From: Katie Kurek [REDACTED]
Sent: 20 December 2018 15:52
To: Samantha Allen
Cc: Planning.Responses
Subject: RE: Planning Consultation on: P/118/18/DOC

APPLICATION NO: P/118/18/DOC

Site Address: Manoss Lea 9 Manor Park Pagham PO21 3JS

TO:	Arun District Council FAO: Samantha Allen
FROM:	Highways, WSCC
DATE:	20 th December 2018
LOCATION:	Manoss Lea, 9, Manor Park, Bognor Regis, PO21 3JS
SUBJECT:	P/118/18 Application for approval of details reserved by condition imposed under P/76/17/PL relating to Condition 3 schedule of materials & finishes and Condition 5 covered & secure cycle parking spaces.
RECOMMENDATION:	☒ Advice ☐ Objection ☐ Modification ☐ No Objection ☐ More Information ☐ Refusal
S106 CONTRIBUTION TOTAL:	£N/A

DRG 8A

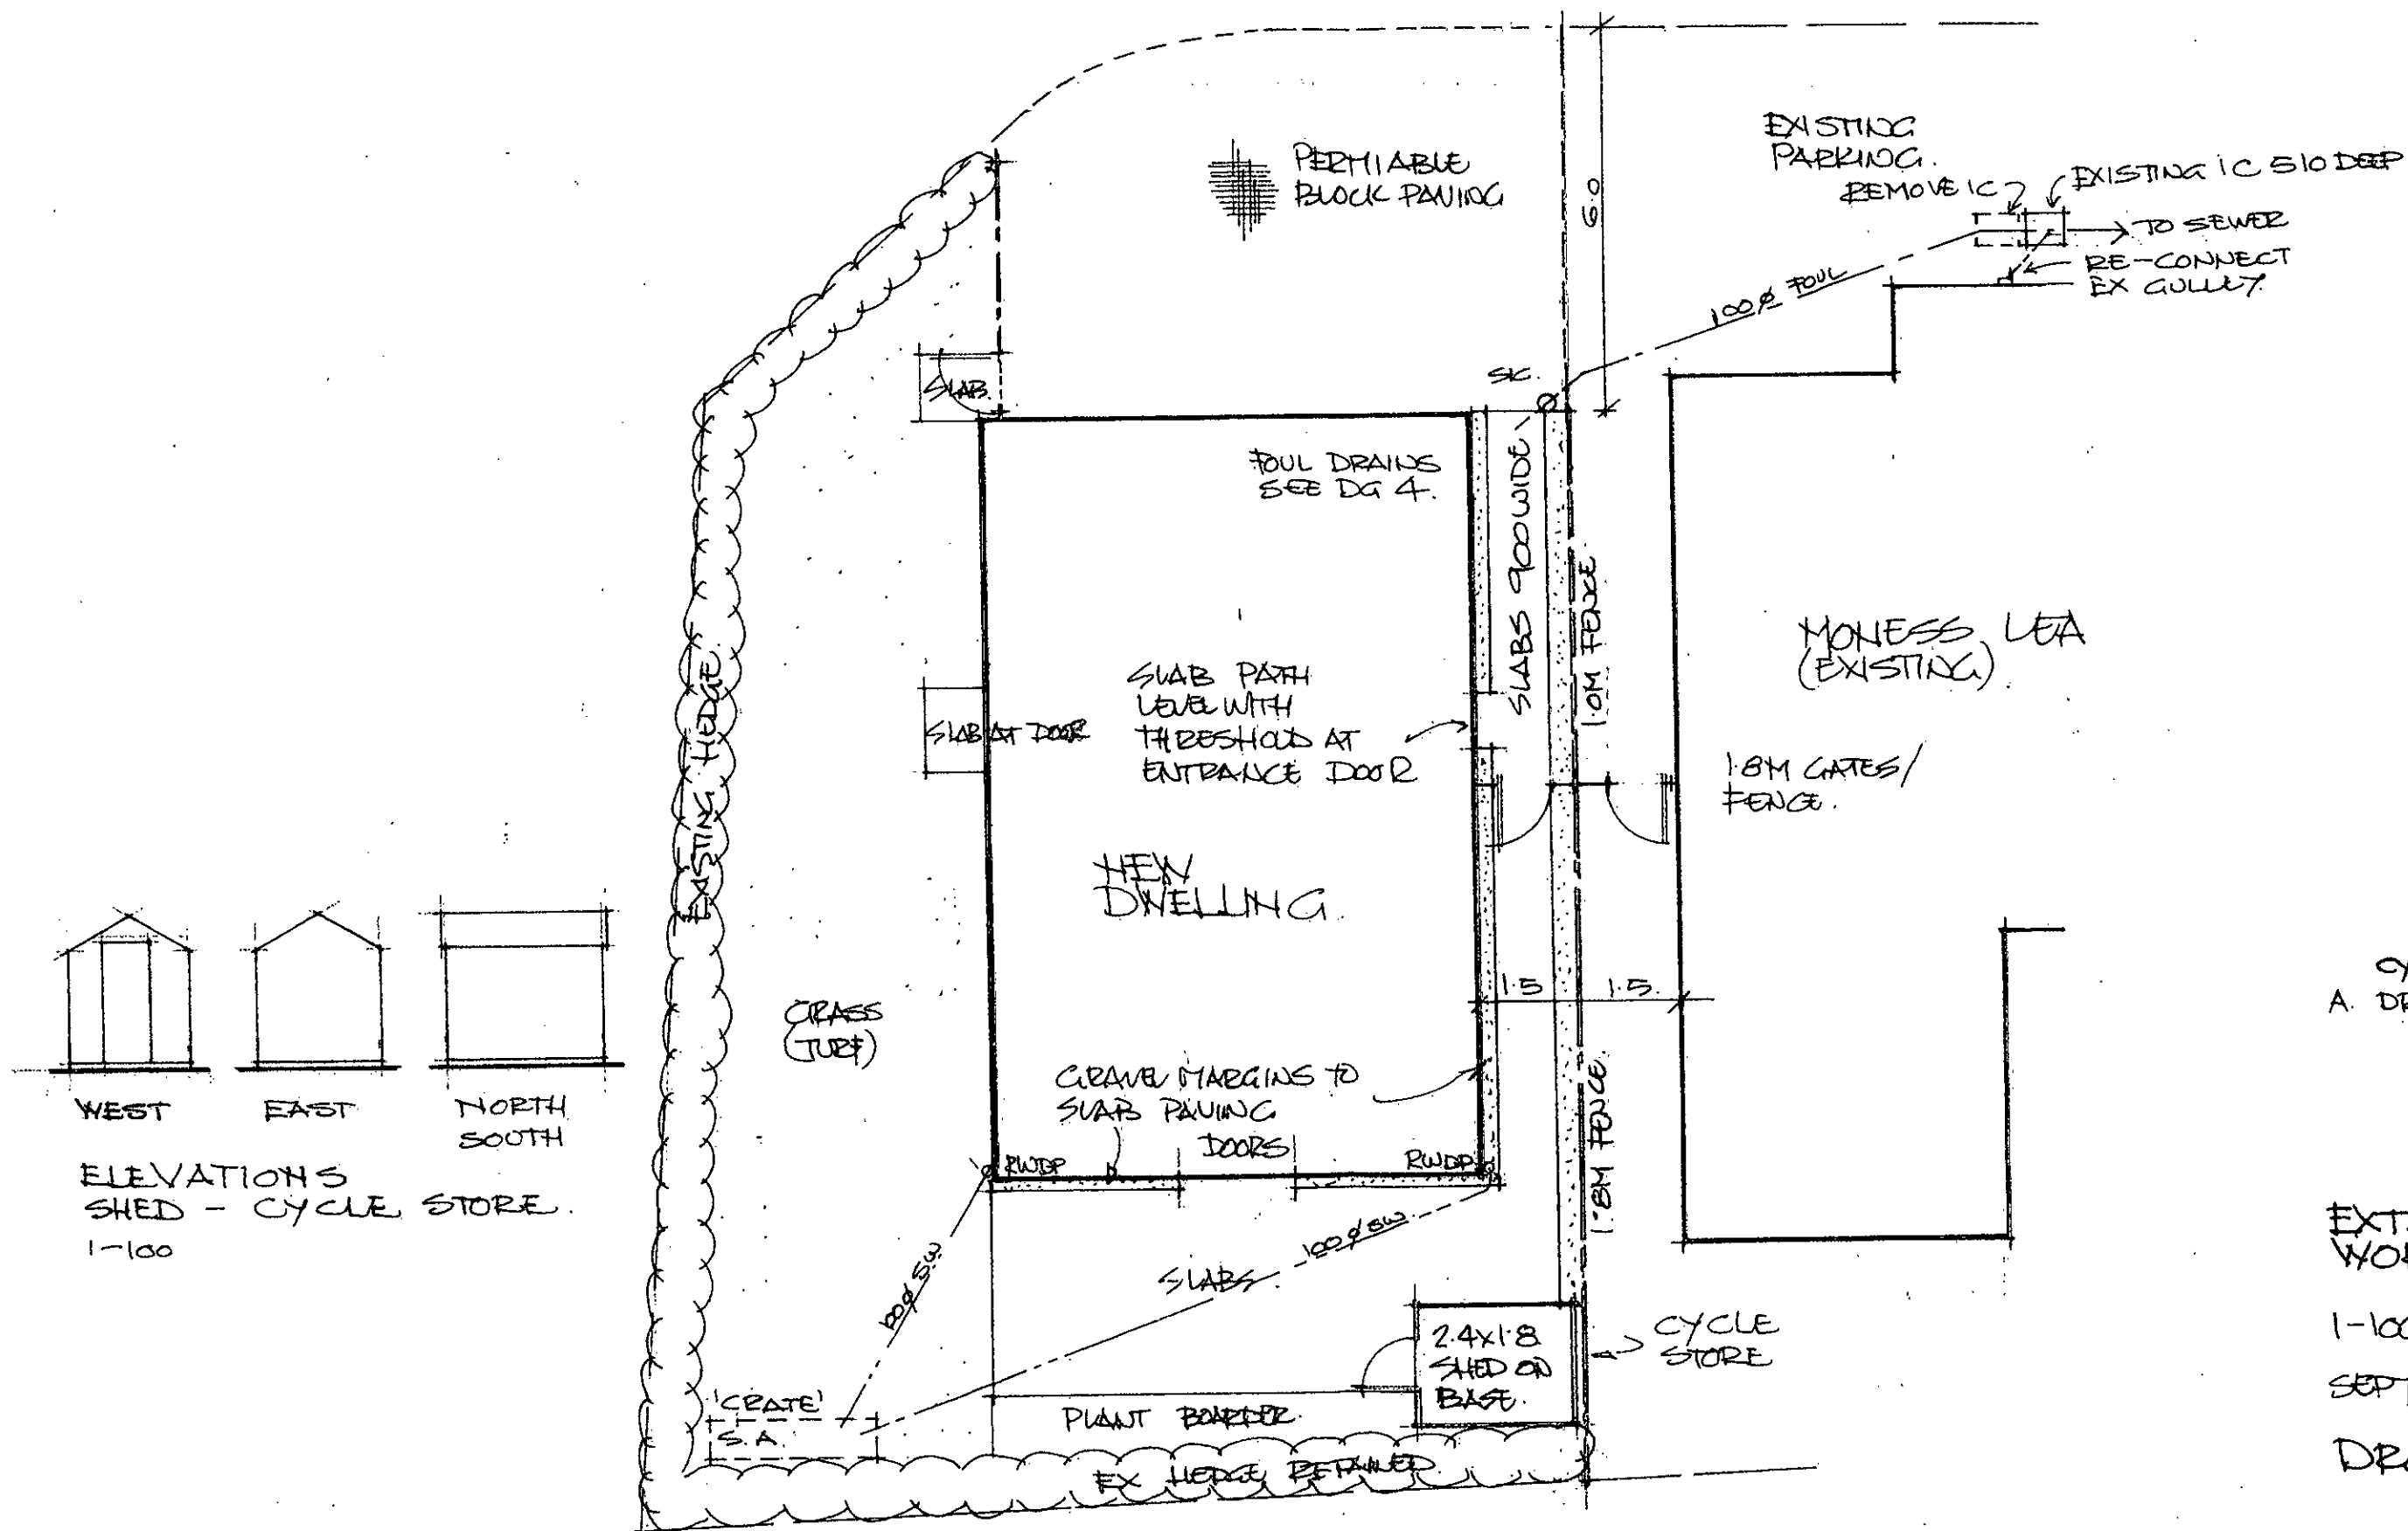
The plans indicate that a shed will be provided in the rear garden to provide secure and covered bicycle storage space. The plans and details pertaining to the condition are acceptable.
